architect marshall

21.10.10

Thomas Stock
Root Projects
Level 5
Kyle House
27-31 Macquarie Place
Sydney 2000

Further to my letter to you of 15.9.10, please find attached the following drawings that reflect the revised additional change to the proposed MCA Redevelopment approved PA as a result of the external envelope swelling to the east and west where structure cannot be relocated. They are the latest "For Construction" drawings with a red layer over the top to point out what has changed. All amendment letters refer to the same changes as shown in the legend in the bottom right hand corner.

PROJECT MCA REDEVELOPMENT 140 GEORGE STREET CIRCULAR QUAY SCALE 1:100 @ B1 DRAWING DESCRIPTION LEVEL 6.2 FLOOR PLAN DRAWING No. A ISSUE DOP/B - A 131

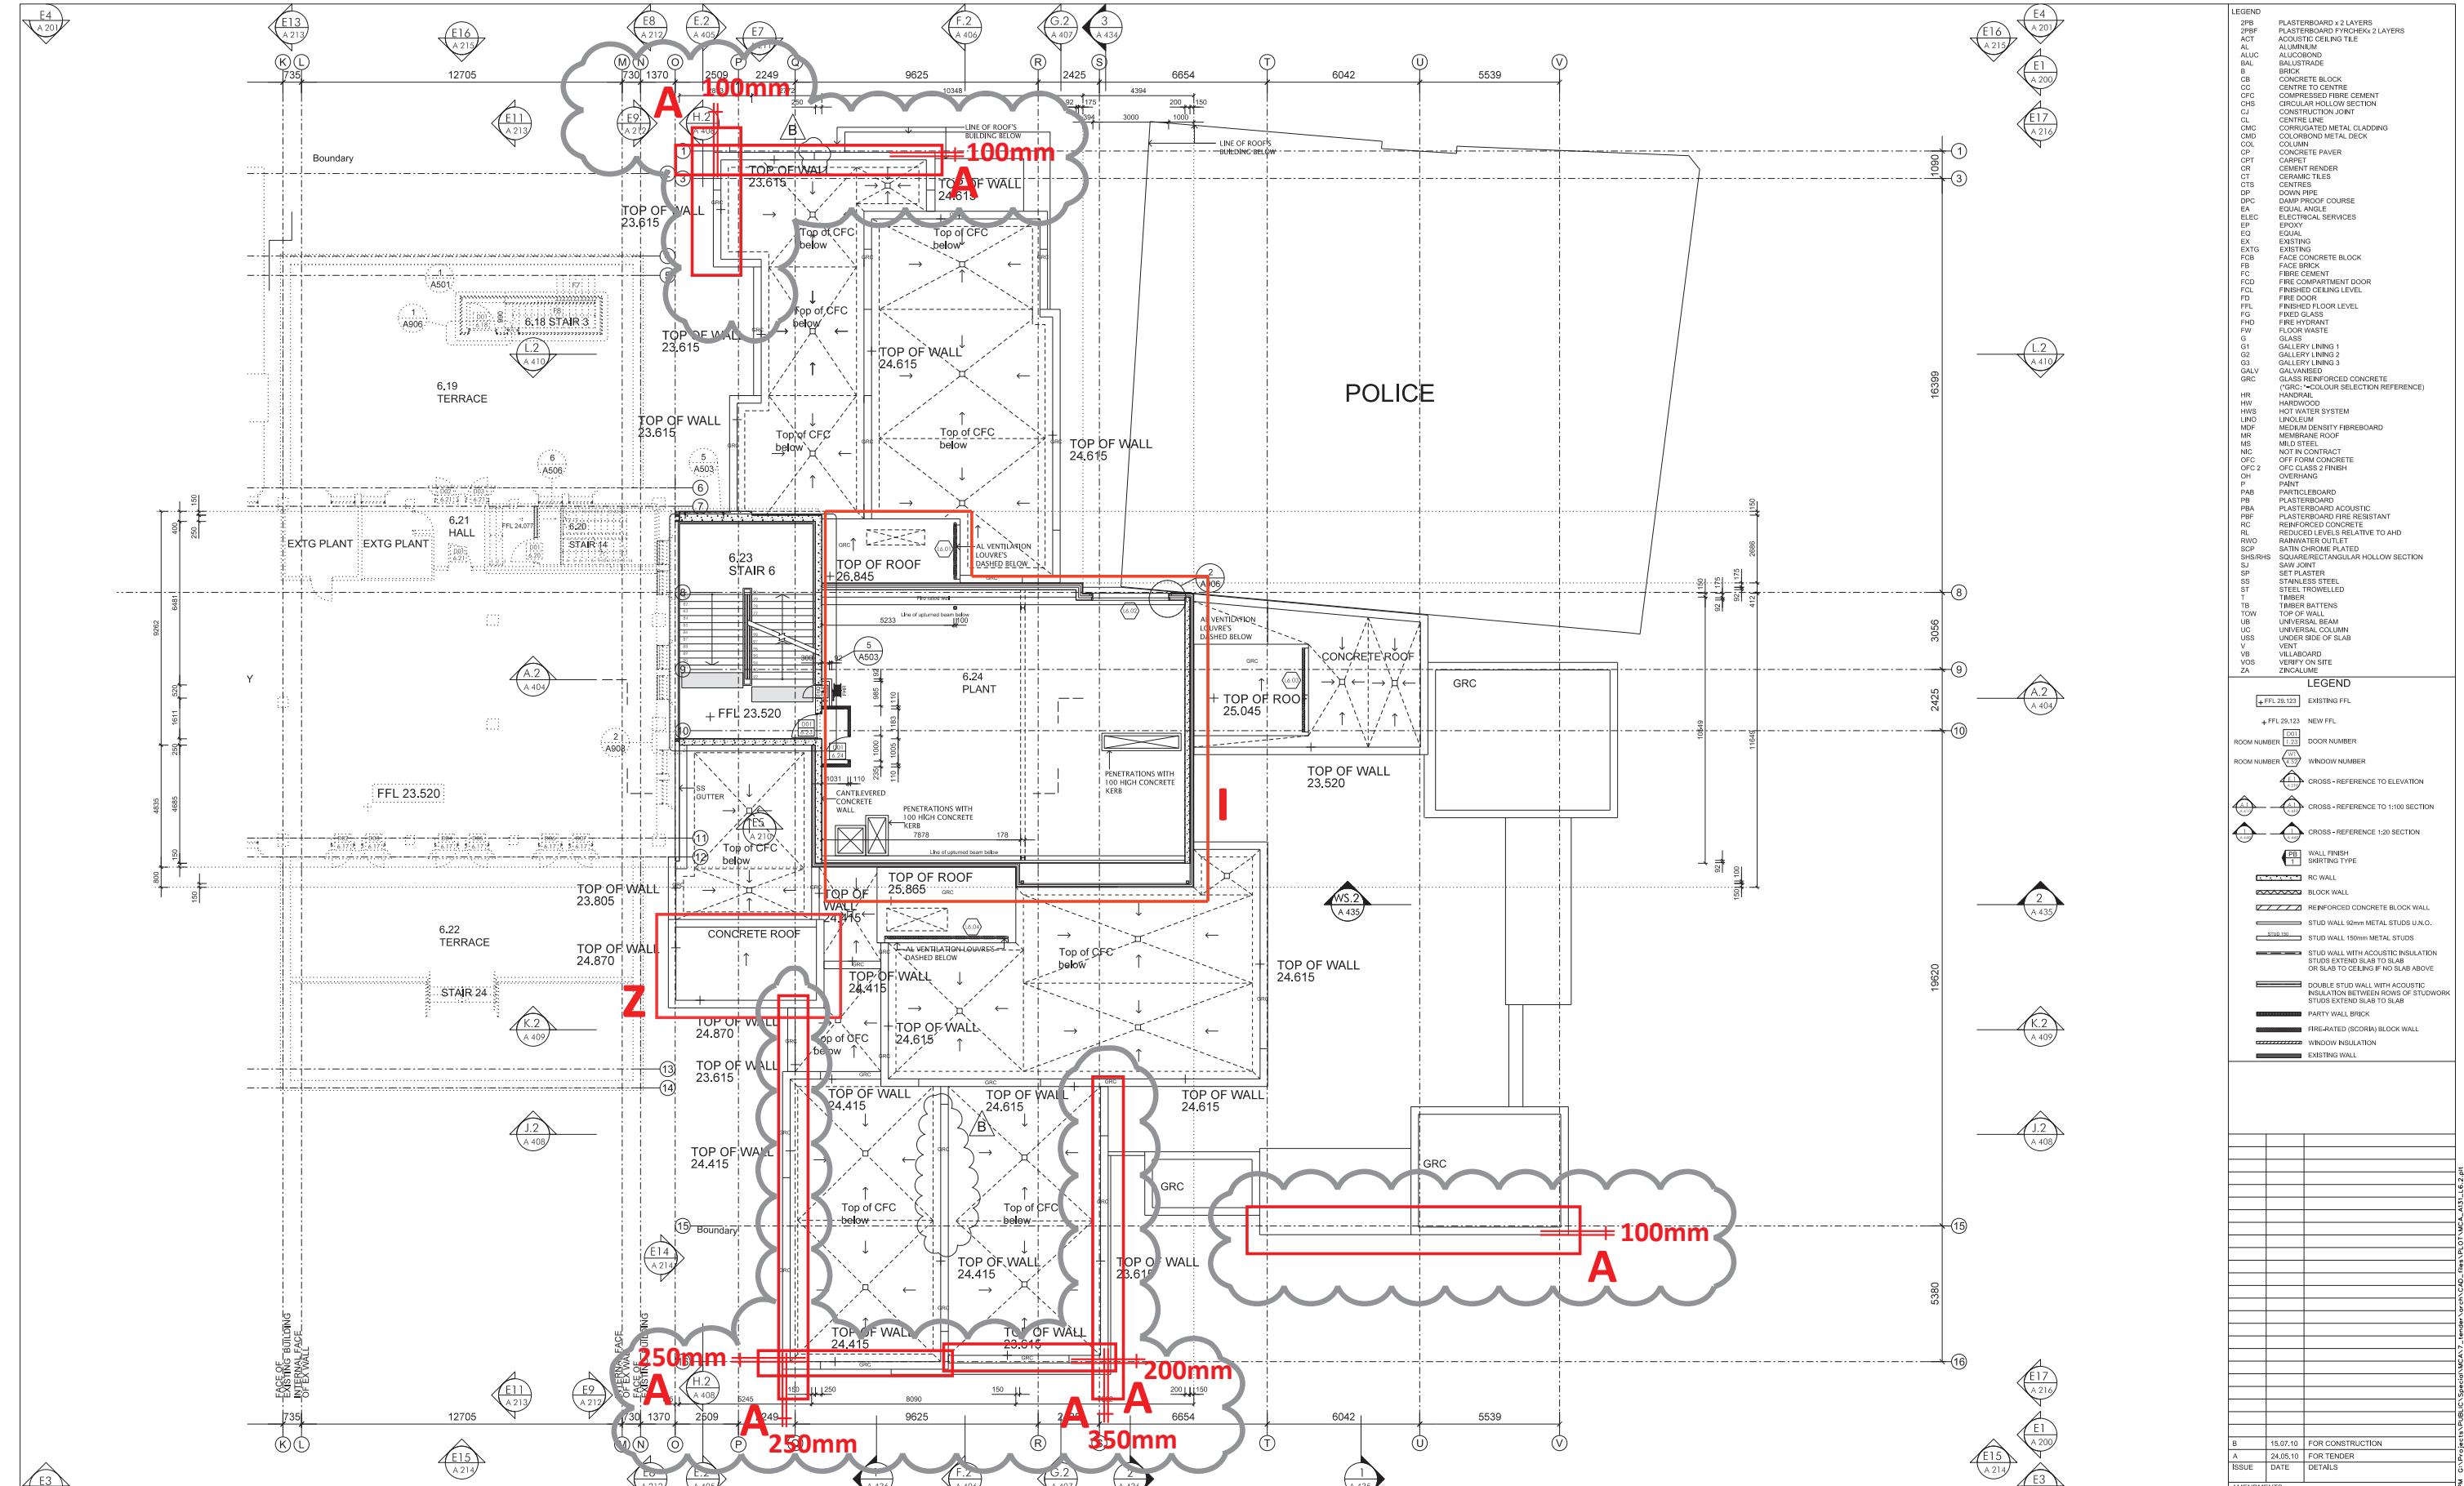
A. Facade swelling.

The external envelope has in some places swelled due to further design development, comprehensive structural design and detailed understanding of the requirements of the cladding system (GRC) as we now have the knowledge of the GRC subcontractor who is now signed up. The swelling has not changed the approved gross floor area ie internal areas.

Over the new entry from Circular Quay, the facade has swollen to the east but not to the north or south. Approval was already granted for the substantial cantilever over SHFA land on this side. The swelling pushes this out slightly as shown.

Over the new gallery to the north (noted as "Gallery 2.4" on the PA drawings and "2.39 Gallery" on the attached), the facade has swollen to the east as this line of structure behind the GRC cannot be moved west. This new gallery has not swollen to the north or west. The east facade of this gallery and the NCCL above have swollen 80mm over the eastern boundary. Where structure has been moved inwards to keep within the boundary on the north face of this gallery to keep it within the boundary, this eastern line of structure cannot be moved west at all.
